Item No. **Report of the Interim Director of Planning, Regeneration & Public Realm**

Address 181 EASTCOTE ROAD RUISLIP MIDDLESEX

Development: Erection of a single-storey side extension including the demolition and re-building of the garage into a side extension for home gym.

LBH Ref Nos: **58606/APP/2022/2359**

PROPOSED FRONT ELEVATION

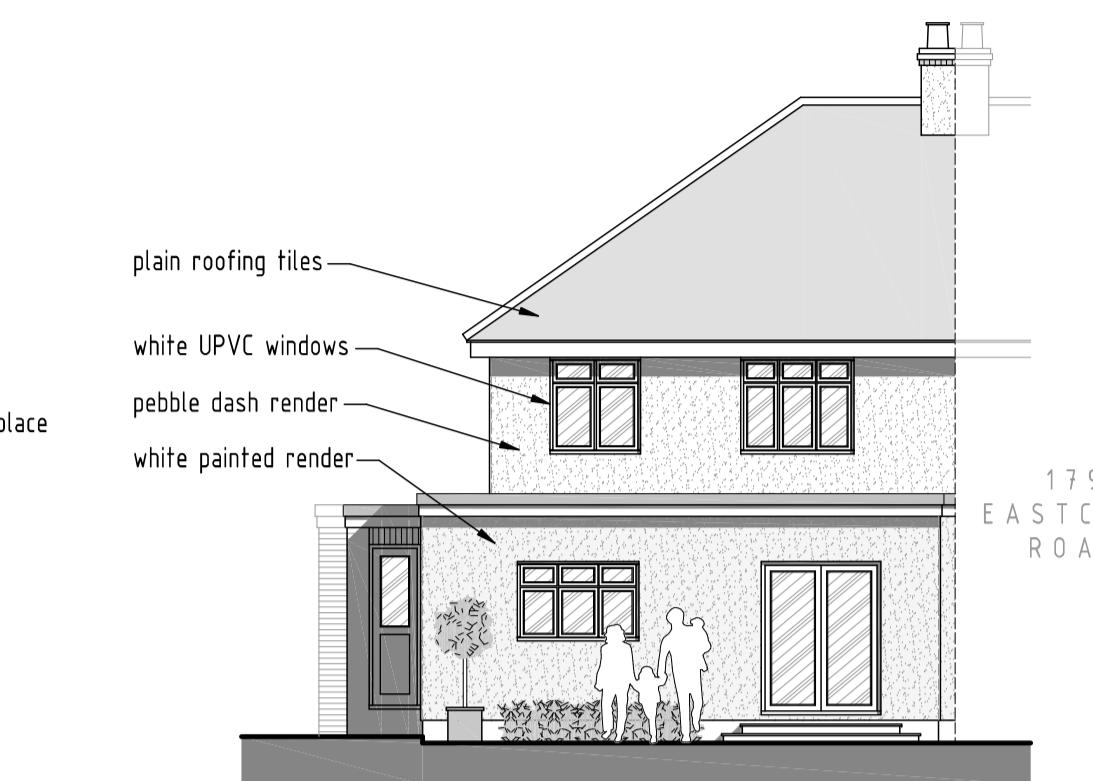
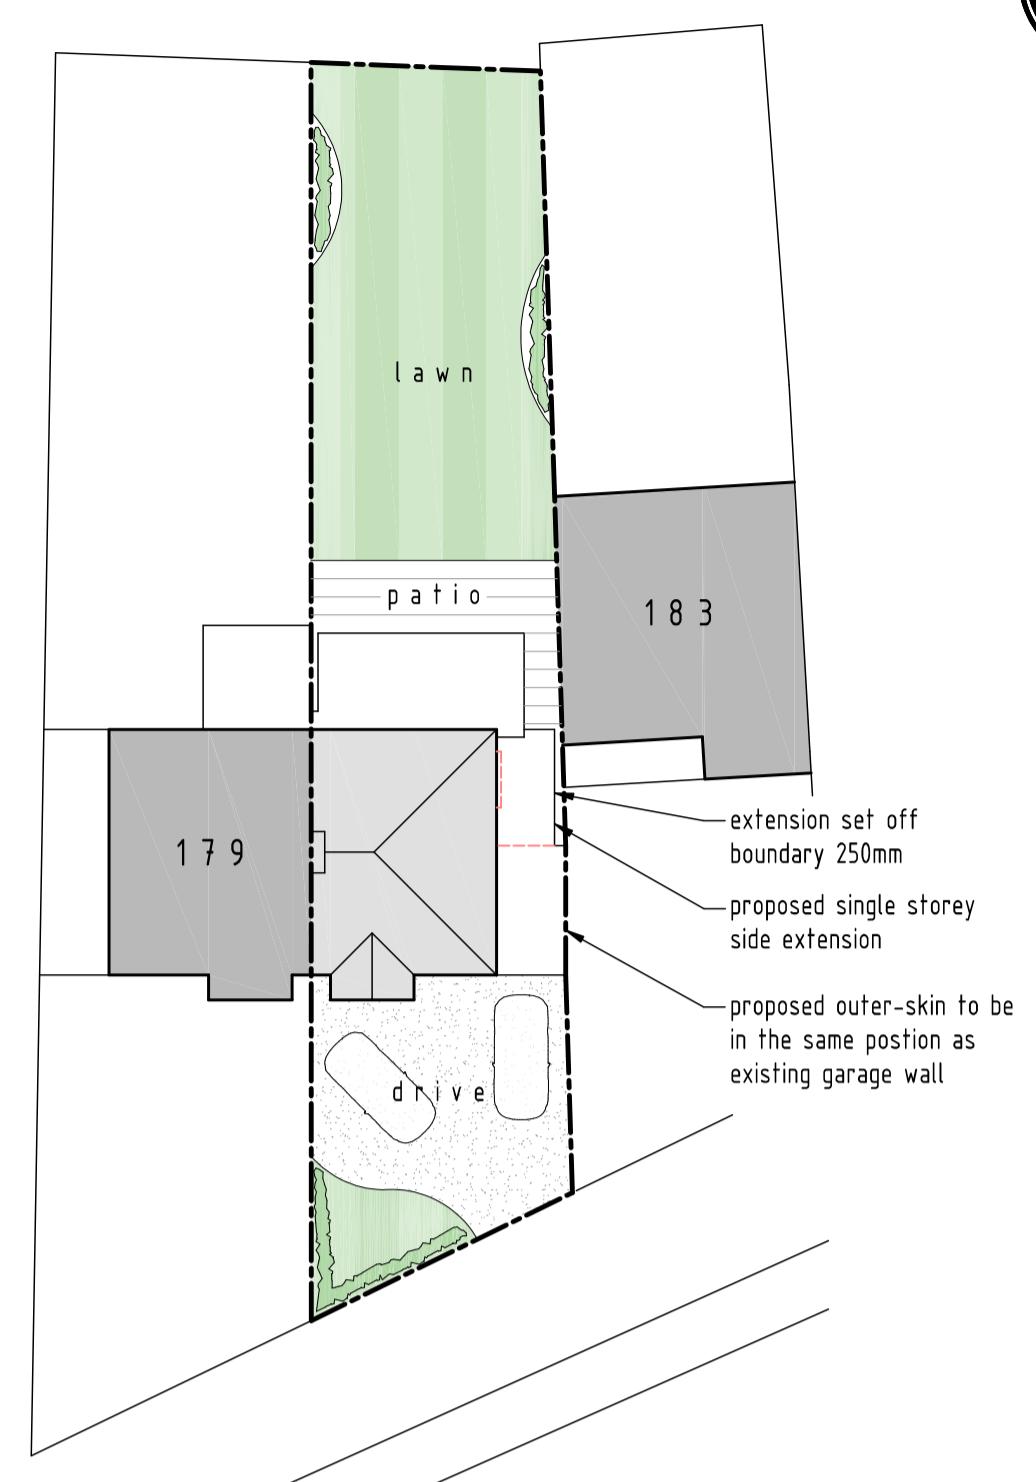
iii) The construction requires a pitched small roof on the front of the new building to blend in with neighbouring houses; neighbour had discussed this with the applicant.

Although the proposed roof would be higher than the existing 2.35m high flat roof, given the proposed flat roof would not exceed 3m in height, this is considered to be acceptable. In terms of design, comments were raised during the public consultation that the proposed roof should have a front pitched roof to match neighbouring houses; whilst there are examples of garages and side extensions with front/side pitched/dummy pitched roofs, there are also examples of garages and side extensions with flat roofs along the street scene. Therefore, given the existing flat roof design of the existing garage (to be demolished and re-built as a habitable room) and other flat roofed garages and side extensions along the street scene, it is considered that the proposed flat roof design of the proposed side extension would be acceptable in this instance and would not cause harm to the character and appearance of the application property, street scene and surrounding area.

Each individual scheme is assessed by its own merit and whether the proposed development complies with the policies set out in the Hillingdon Local Plan. The impact of the proposed development on the character and appearance of the street scene and surrounding area has been discussed in Section 5 of this report.

PROPOSED GROUND FLOOR PLAN

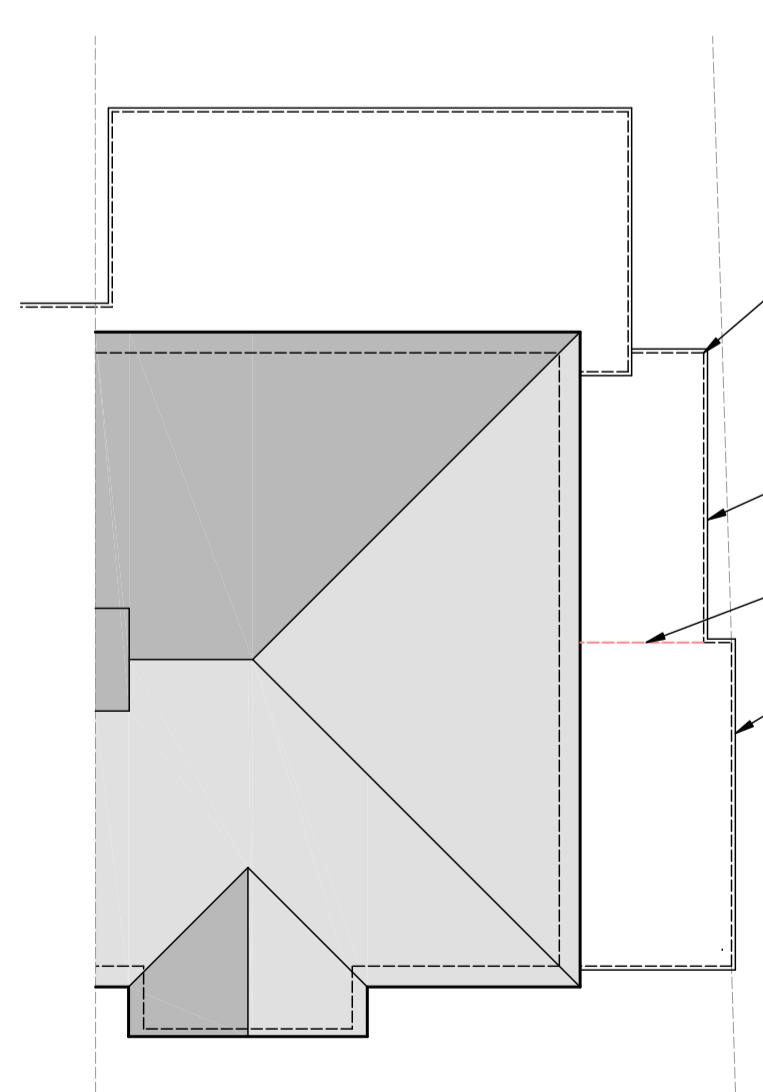
v) 250mm gap shown on new construction makes it difficult to maintain garage gutters. The 250mm gap requires closing panel between the garages for security.

A separation distance of 0.25m between the side of a property and the site boundary is a typical arrangement for side extensions within the London Borough of Hillingdon; access for maintenance purposes is not considered a material planning matter. The installation of a fence panel for security purposes can be done without planning permission.
